DOC20/918215
Senders ref: SSD 10438

Subject: Notice of Exhibition – Waterloo Metro Quarter Over Station Development – Basement (SSD 10438)

Thank you for your e-mail dated 5 November 2020, inviting Environment, Energy and Science Group (EES) in the Department of Planning, Industry and Environment (DPIE) to comment on the Notice of Exhibition for Waterloo Metro Quarter Over Station Development – Basement. EES has reviewed the relevant documentation and make the following comments.

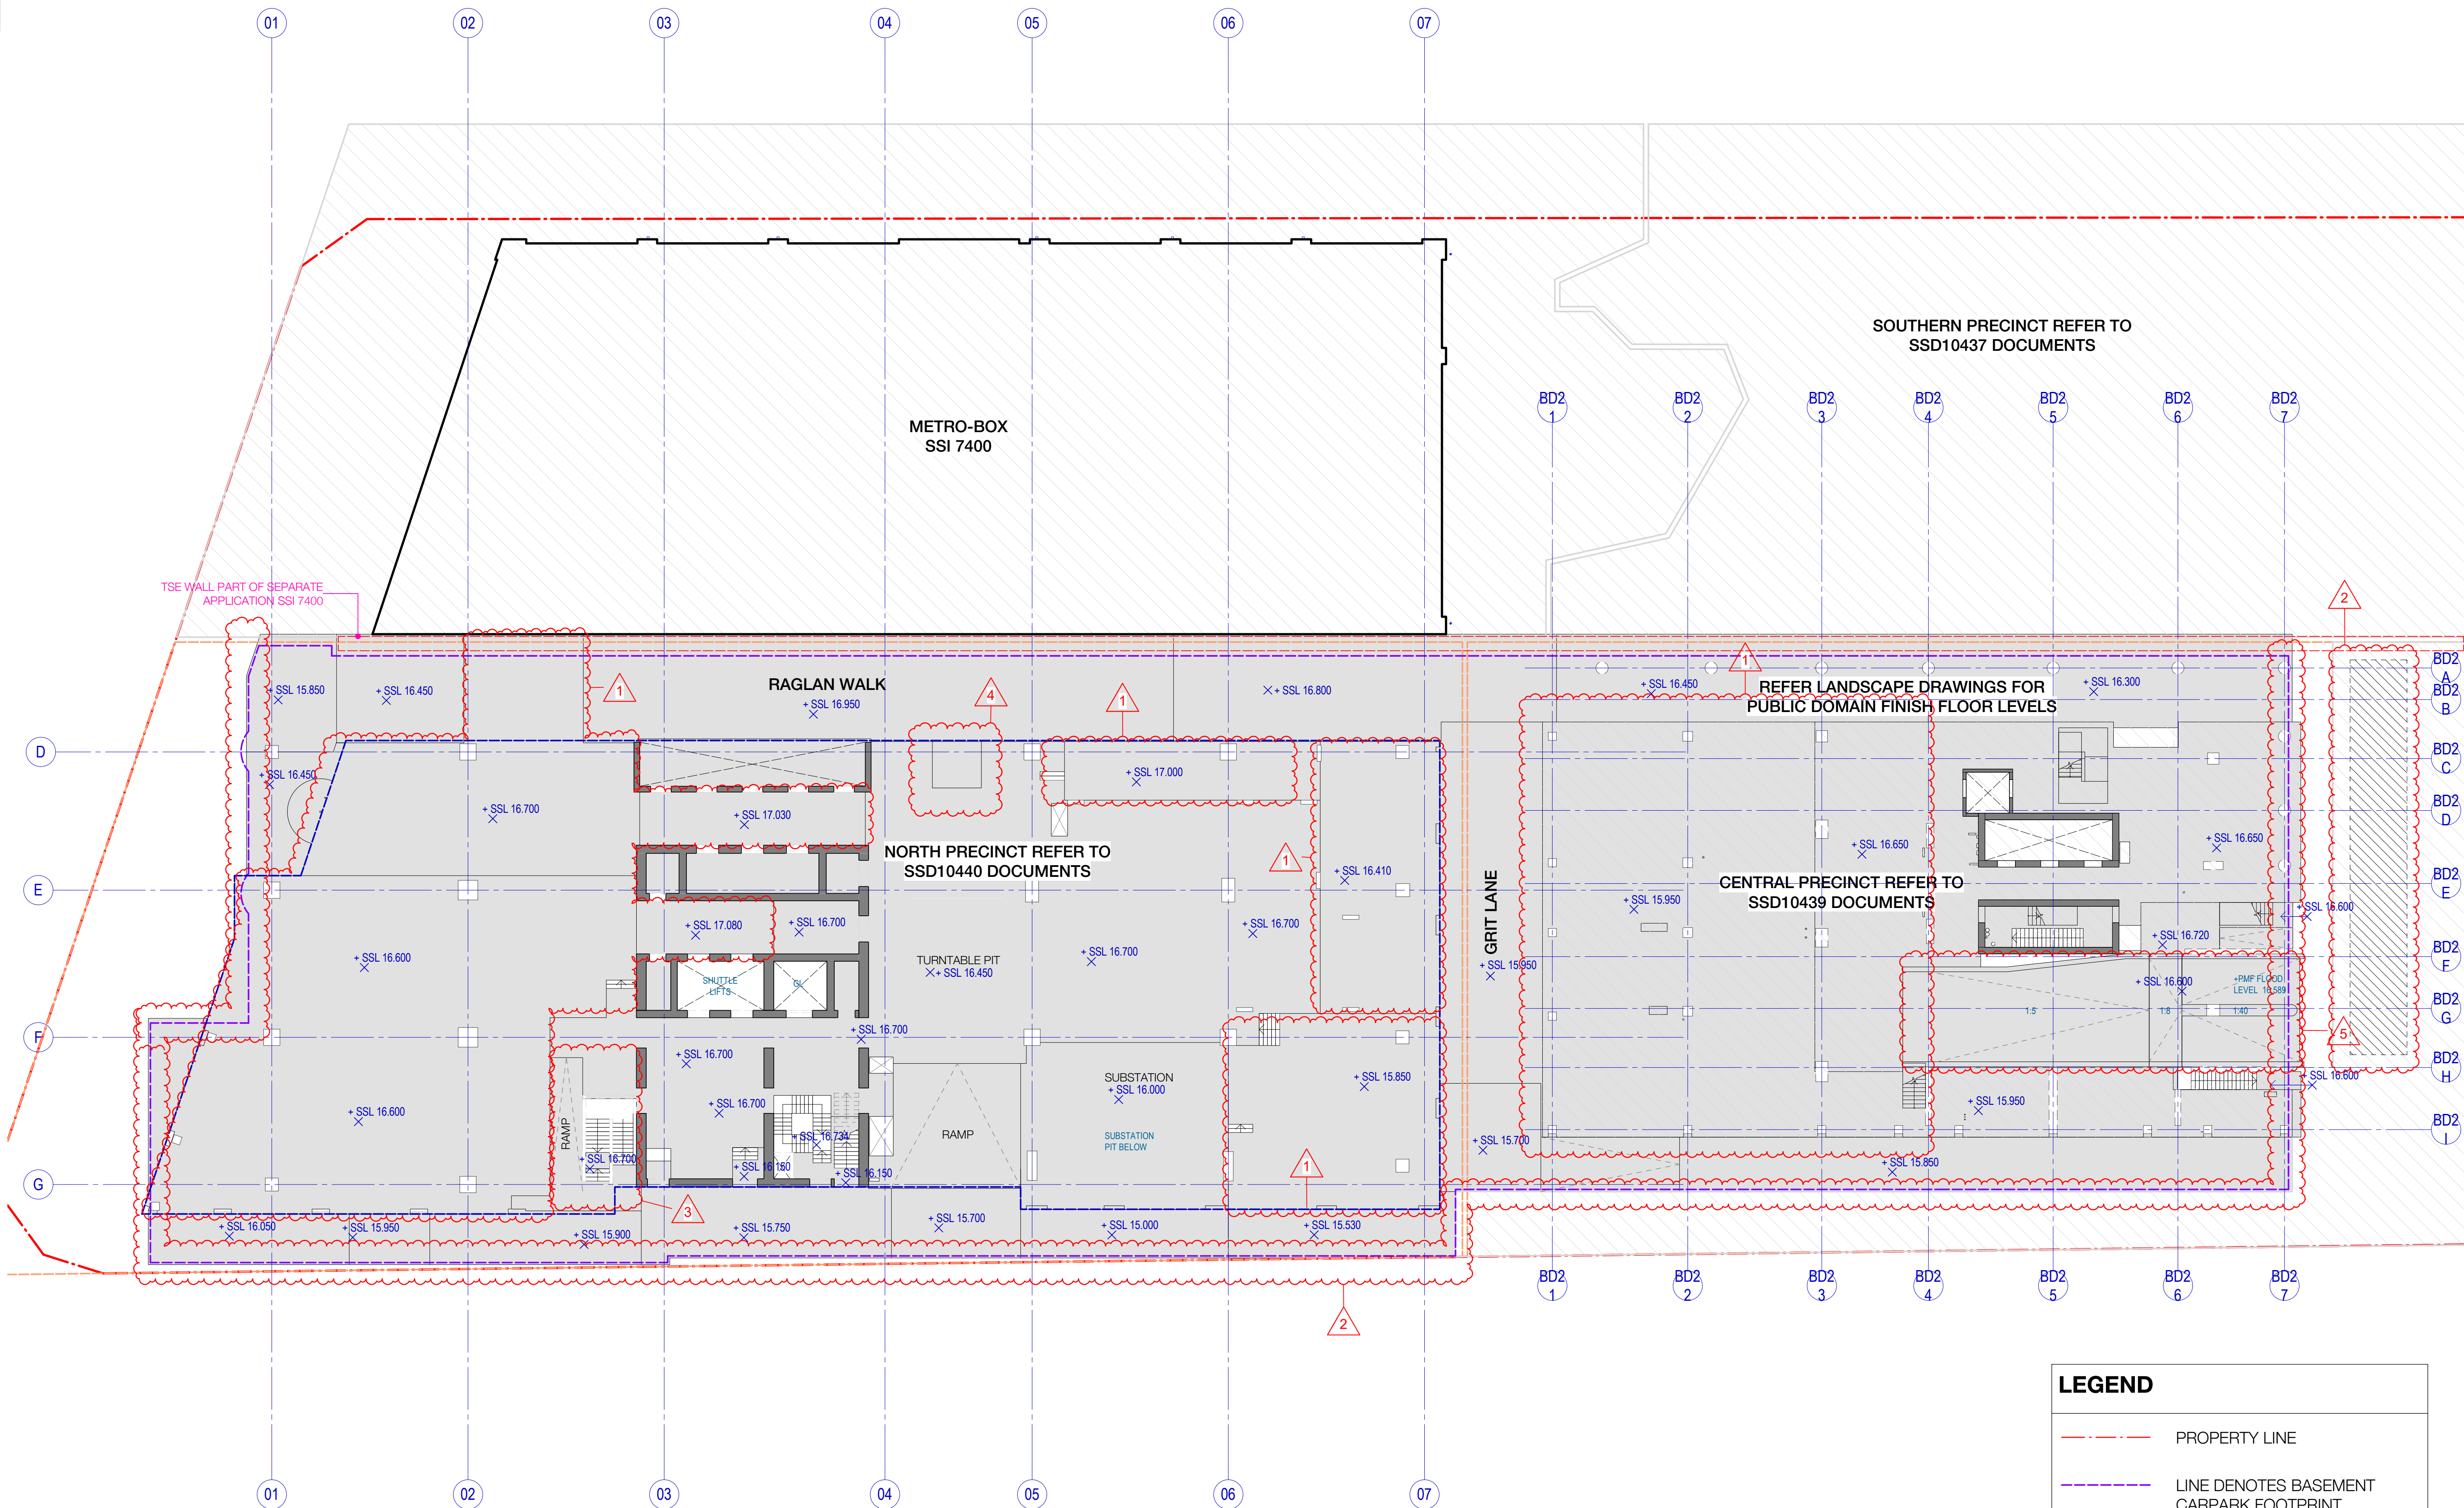
From the documentation provided, the proposal appears to comply with the floor and driveway crest level requirements. However, insufficient information has been provided to demonstrate that Area 7 (the fire stair west of the basement driveway ramp) complies with the requirements as no floor level is available on the drawings and the stairs exit at ground level, which is below the PMF.
